# CITY OF ALBUQUERQUE

**Re: Winfield TI,  
7501 Meridian Pl. NW Suite B-1  
Request for Certificate of Occupancy  
Transportation Development Final Inspection  
Engineer's/Architect's Stamp dated 9-05-18 (K10D023G)  
Certification dated 10-31-18**

5 BIKE POST DETAIL
1"=1'-0"

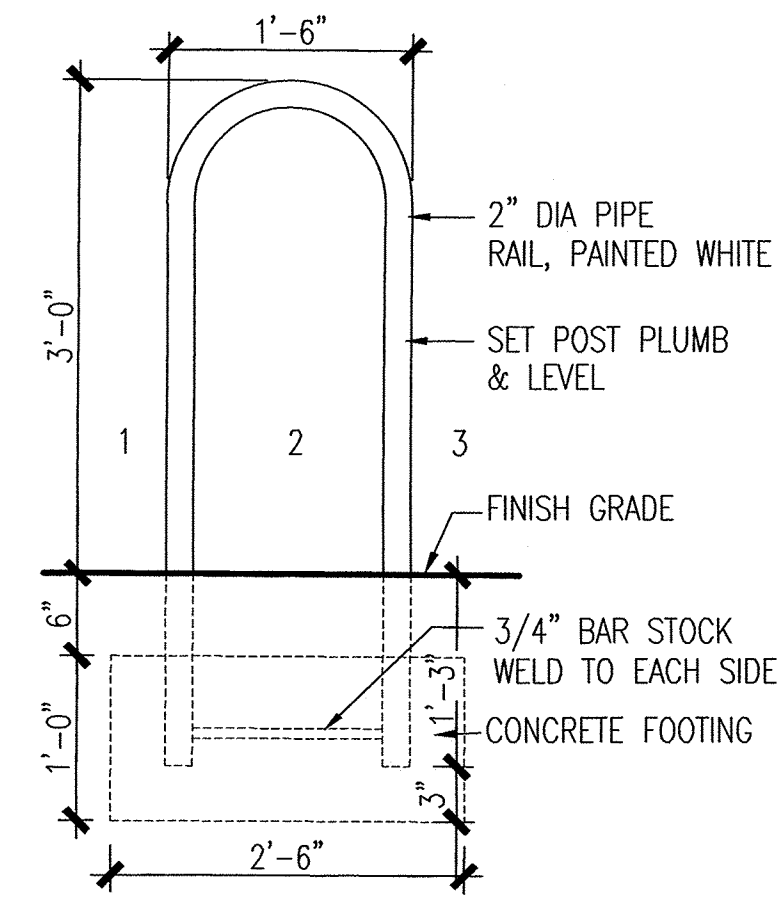
1. Please add motorcycle spaces and signs per approved TCL plan.
2. Please add Bicycle Rack.
3. Please remove construction debris and equipment.
